21 February 2019

Anthony Witherdin
Director, Regional Assessments
Department of Planning & Environment
320 Pitt Street
SYDNEY NSW 2001

Huntlee DA Modification 10 – Response to Recent Comments

Figure 4 | Proposed modifications under Mod 10

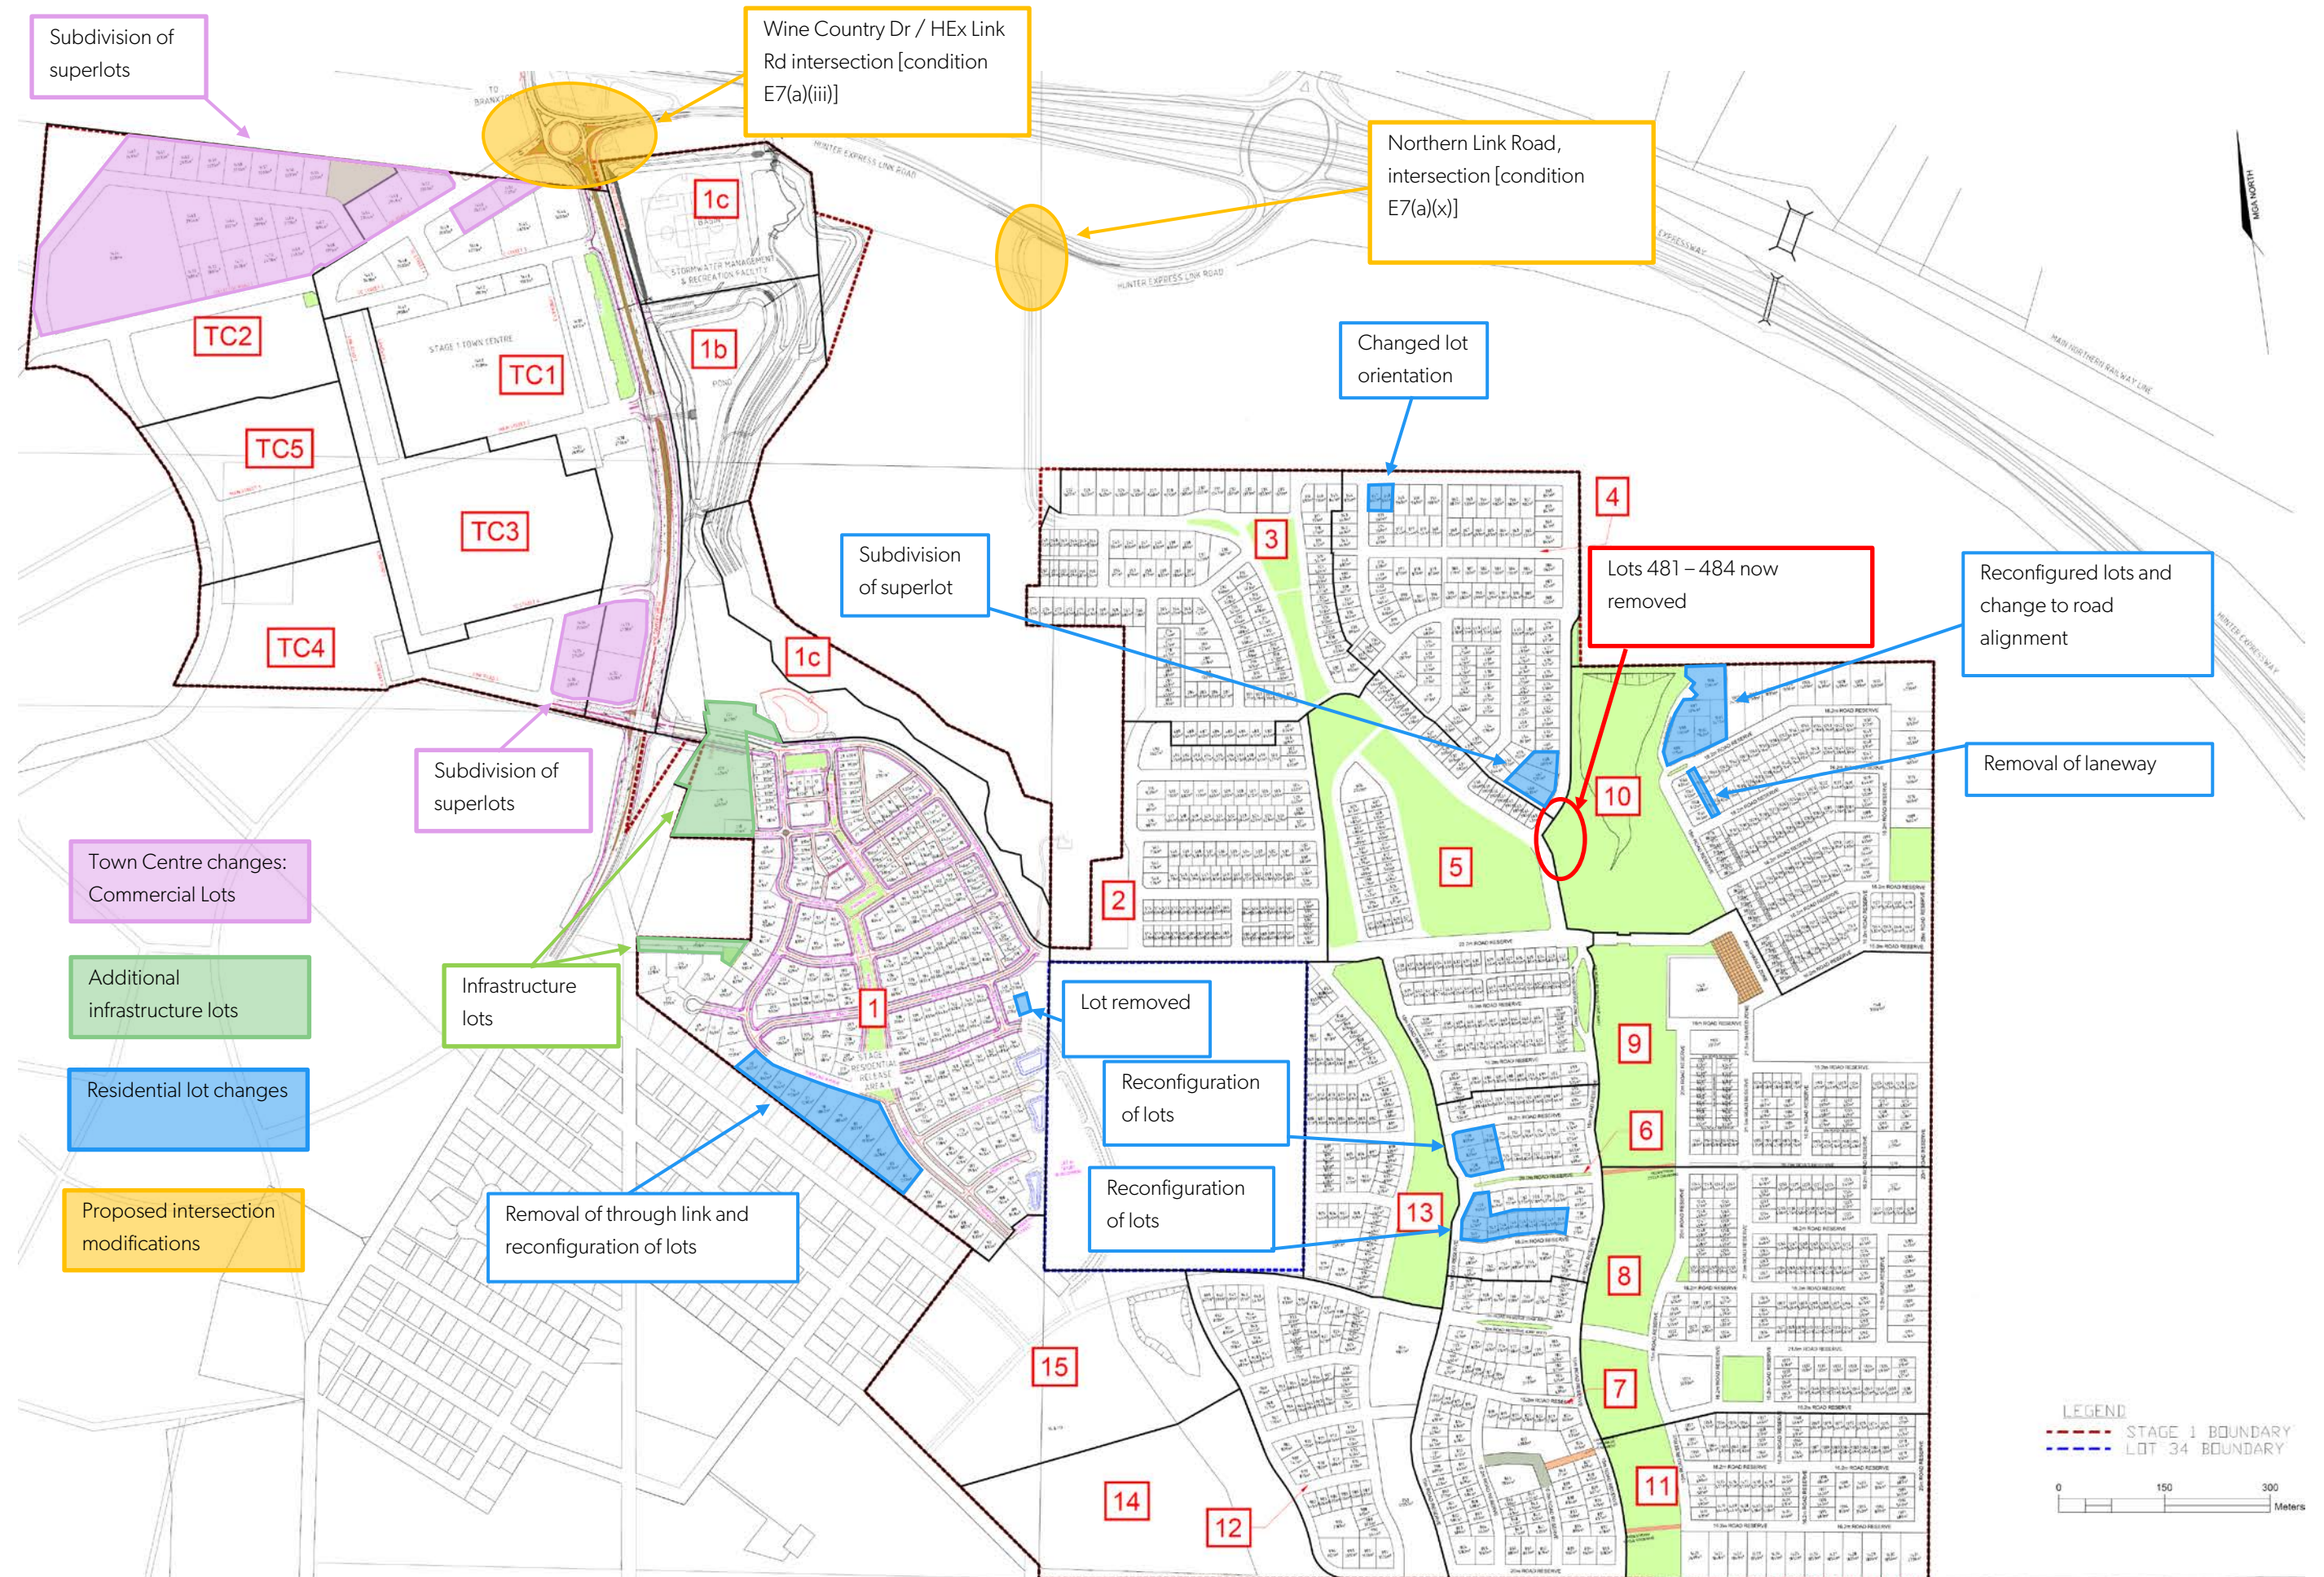
To enable a thorough assessment, the Department requests an overall plan showing all of the proposed changes (through clouds, red text etc). There are still a number of proposed changes that aren't clearly highlighted on the submitted plan. The Department is also still unclear about the lot numbers. It would be appreciated if these could be clarified again and reflect the overall lot numbers that are shown on the submitted masterplan.

The Department raises concerns with the new proposed Lots 481 to 484. Please justify the encroachment of the lots into the public open space/riparian land, when the proposed lots are inconsistent with the rest of the subdivision layout and will erode the provision of perimeter roads along the riparian corridor. Please also demonstrate an appropriate building envelope can be provided outside the environmental constraints on these lots, including flooding and bushfire constraints, for the Department's consideration.

Modification 10 proposes to reduce the lot size and increase the number of lots in area of Precinct 10 indicated below. The Department raises concerns that Lot 1000 will not be able to accommodate a reasonable building envelope outside the bushfire risk from the north. Please consider amending the lot layout to address this issue for the Department's consideration.

Two additional plans have been provided clarifying the changes made to the masterplan in red markup and also confirming the total number of lots which is summarised below.

- Total residential lots - 1427
- Total commercial/mixed use lots - 43
- Total Infrastructure/community/ other lots - 8
- Total numbered lots - 1478

The four new proposed lots are not located within the riparian corridor as indicated by the Departments comment. The provision of large lots in areas which back onto open space/bushland is consistent with the subdivision design elsewhere within the Masterplan, the four proposed lots are also diagonally opposite three other large lots which will create a small area of high quality housing located next to the riparian corridor and a future local sports field.
